Application for Planning Permission for Works or Extension to a Dwelling

Development: Demolition of existing garage/store and utility room and construction on the same footprint of a guest room and utility room. (This application may affect the character and appearance of the Angmering Conservation Area).
Location: Russetts High Street Angmering BN16 4AE

BLOCK PLAN SCALE 1/500
Proposed extension is shown shaded

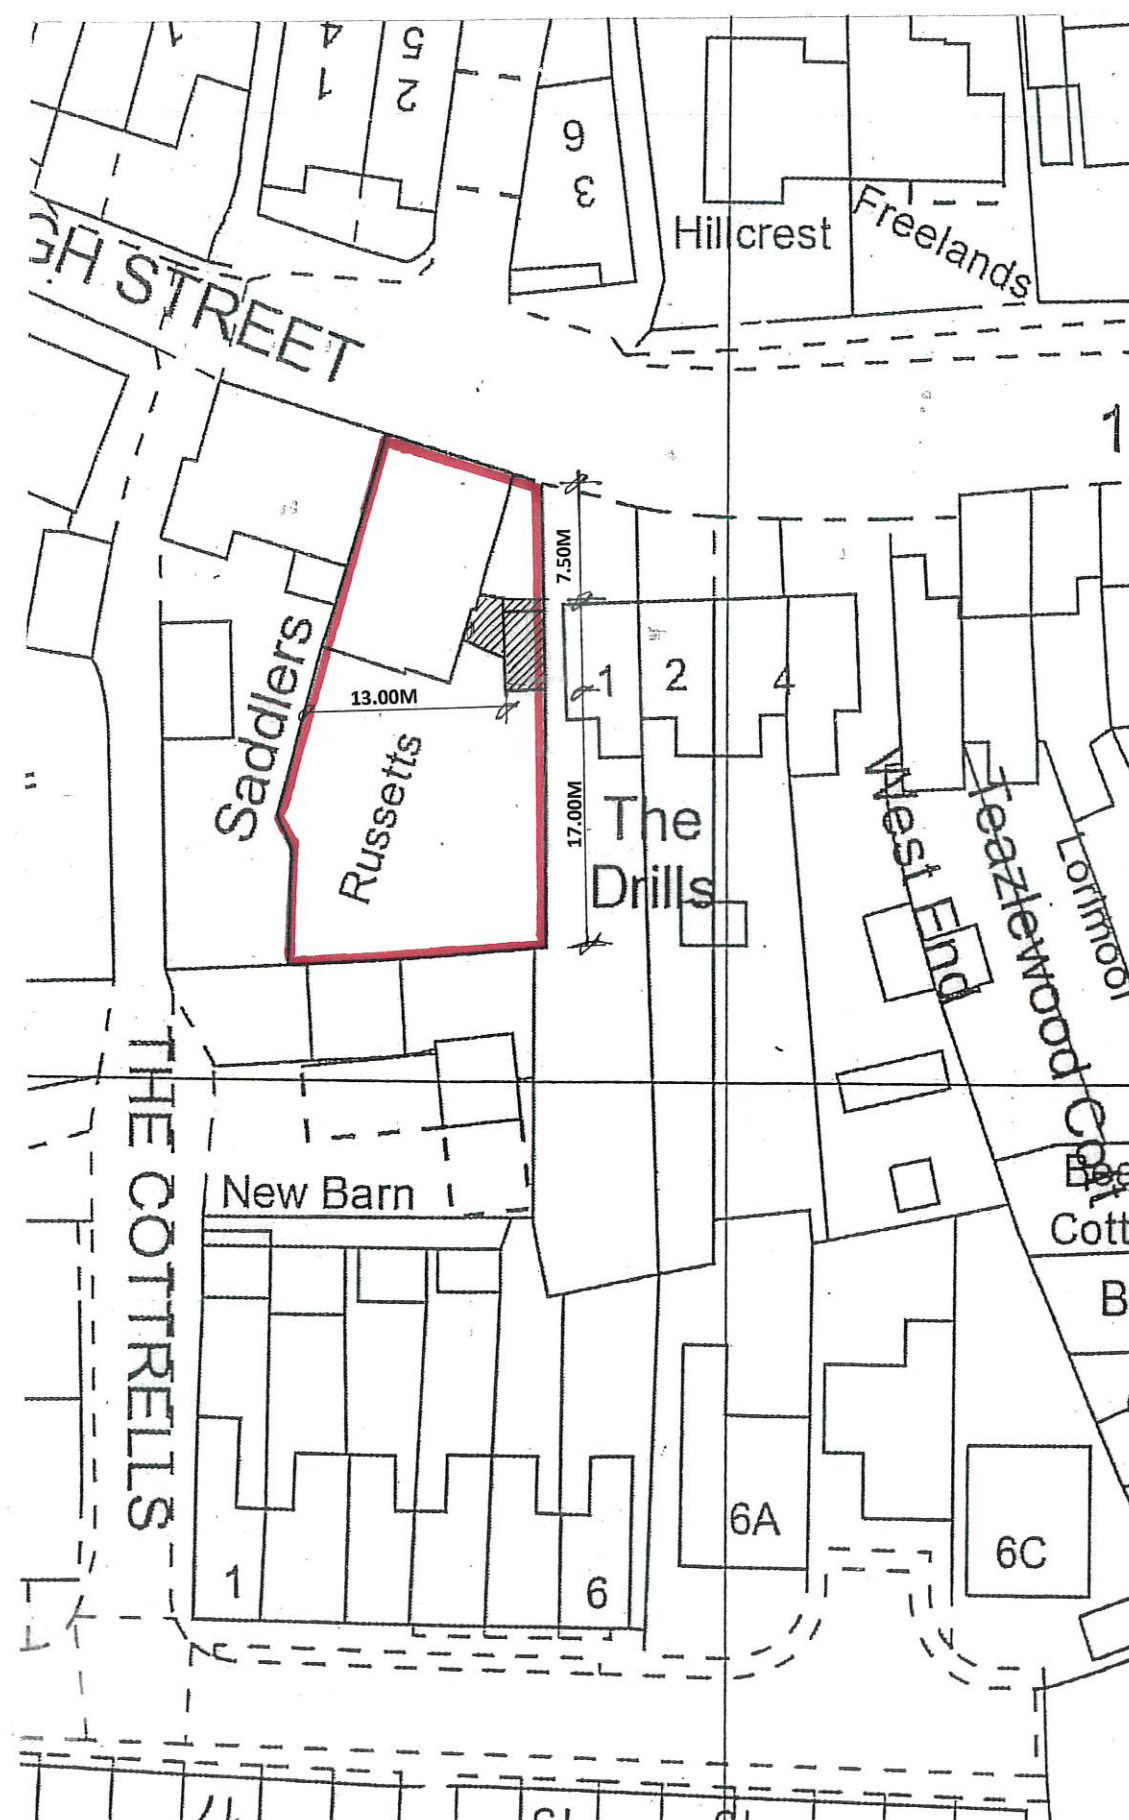
Block Plan

You are required to have dimensions from the proposed extension(s) to all site boundaries. Please amend

**EXISTING ELEVATIONS
GARAGE AND LOBBY**

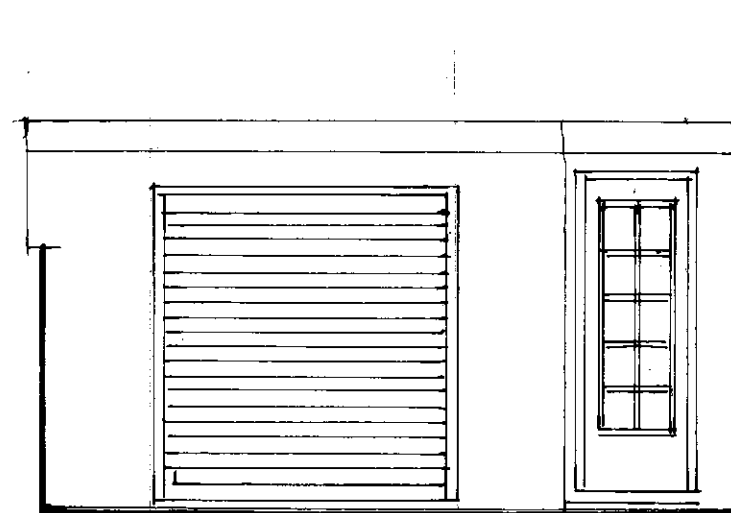
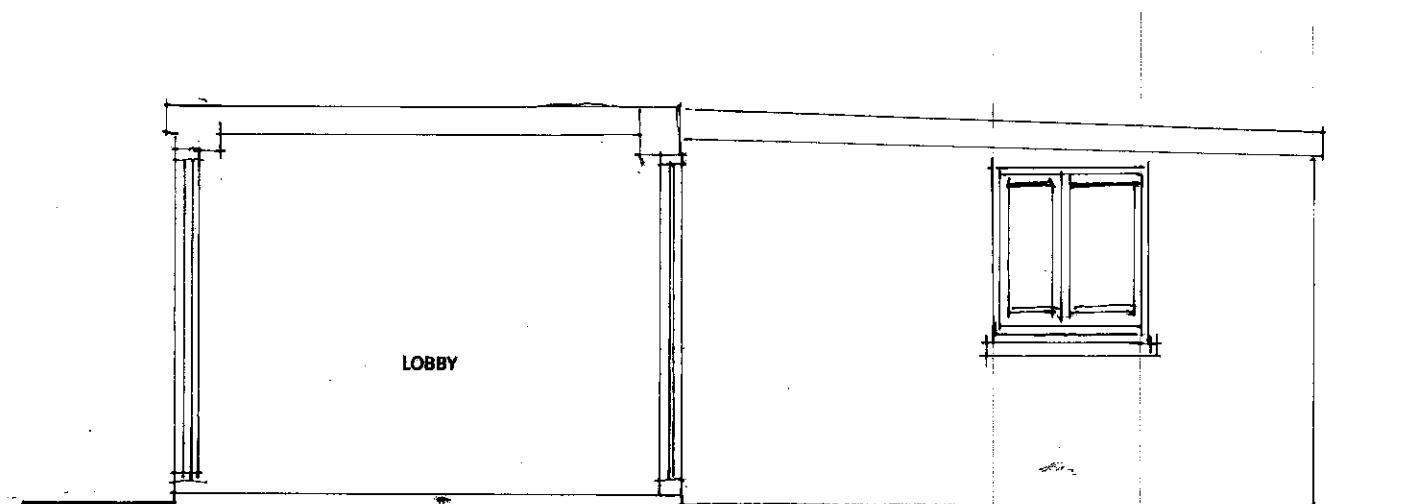
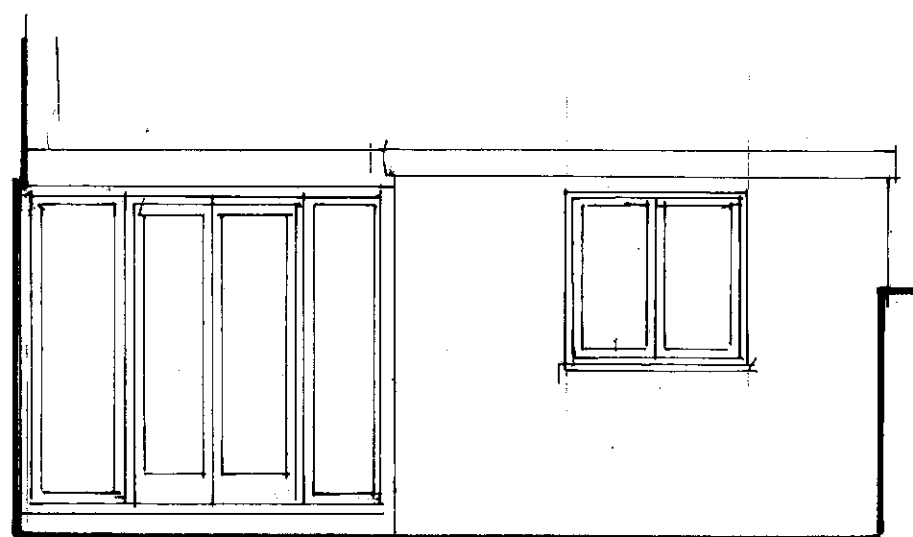
Elevations

Please submit electronic plans in pdf format clearly labelled existing elevations at a scale of 1:50 or 1:100. Further details can be found in the Validation Requirements List.

Please add a scale bar to all the plans and elevations.
